Your Ref: OWPC19372
Our Ref: FP/99/18/HH 26-04-2018
Please ask for:
Zac Denton

Town & Country Planning Act 1990 (as amended)
Town & country Planning (Development Management Procedure) (England) Order 2015

Retention of timber outbuilding/shed to front garden
50 Crossbush Road Felpham

| FLOOR PLAN & ELEVATIONS                                                                                   |                              |

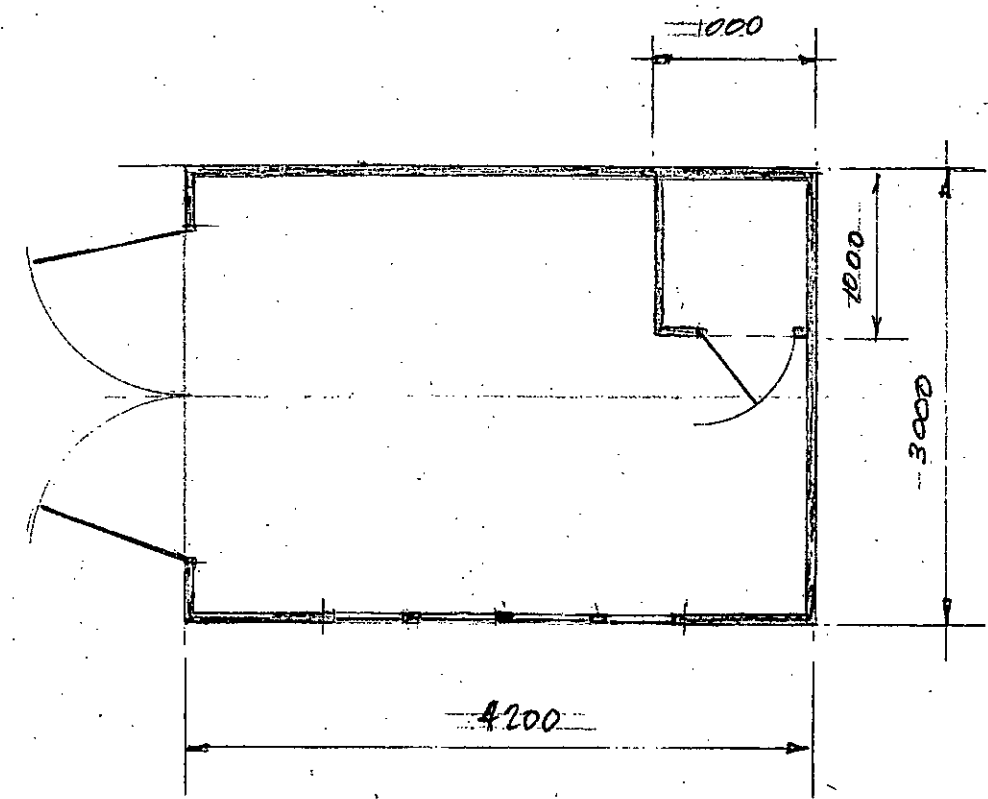
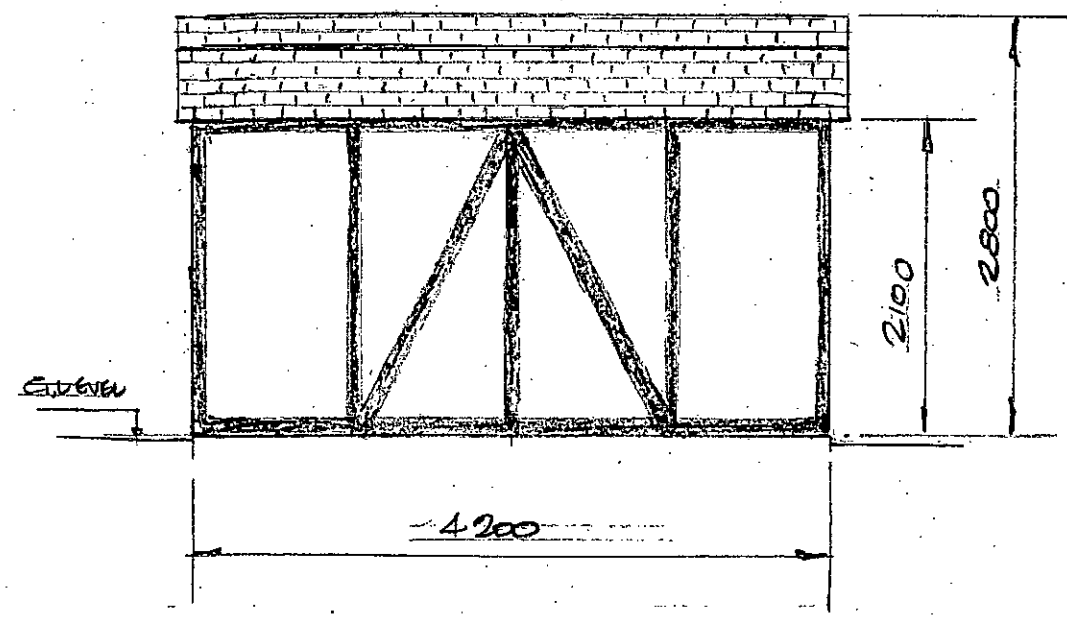
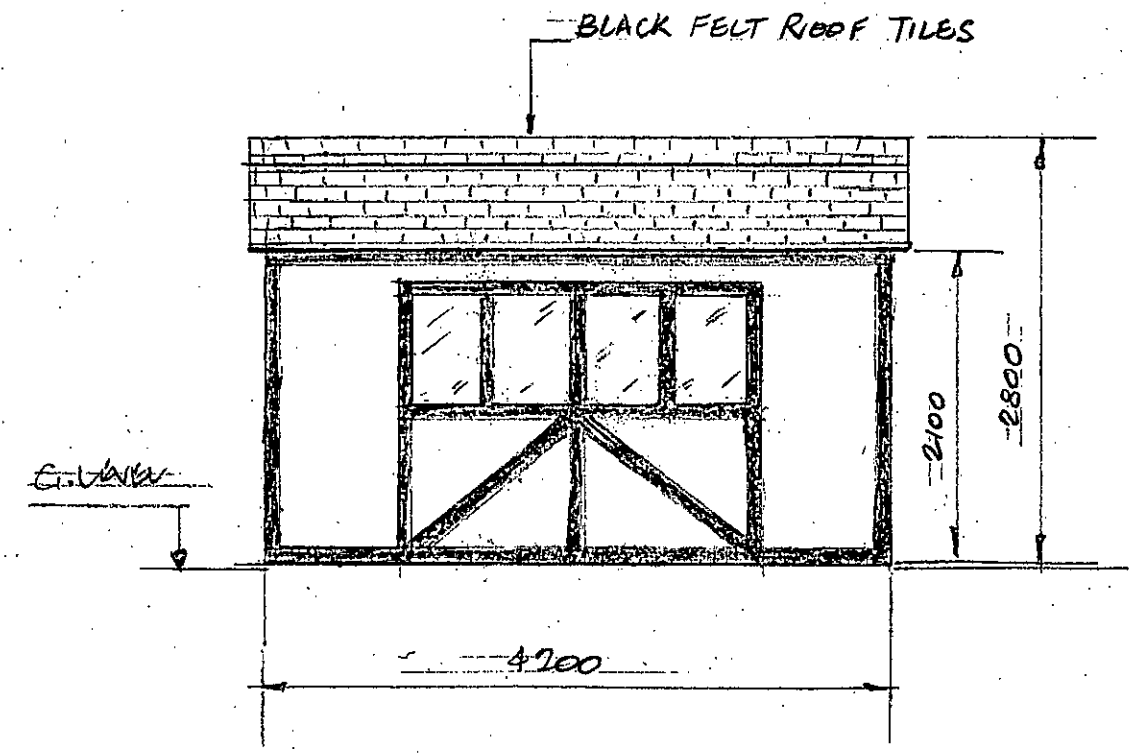
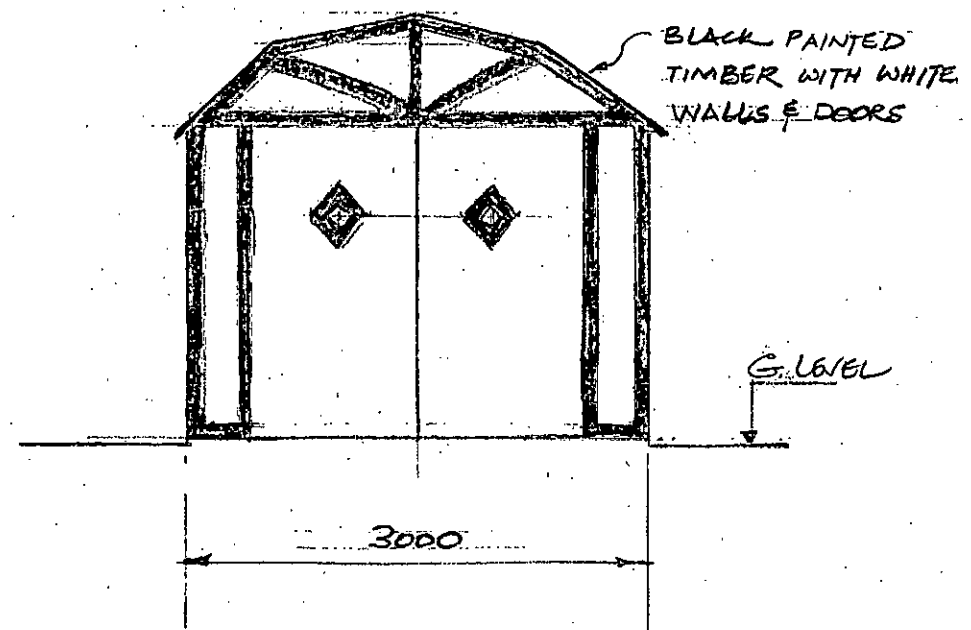
- 1. too close to boundary wall*
- 2. timber construction poses a fire hazard - as the owner is a professional builder and he could store flammable materials inside.*
- 3. the plan does not show the full impact of the garage / outbuilding - the plan is not to scale and does impact on the off road parking*
- 4. reduction in light in our sitting room*
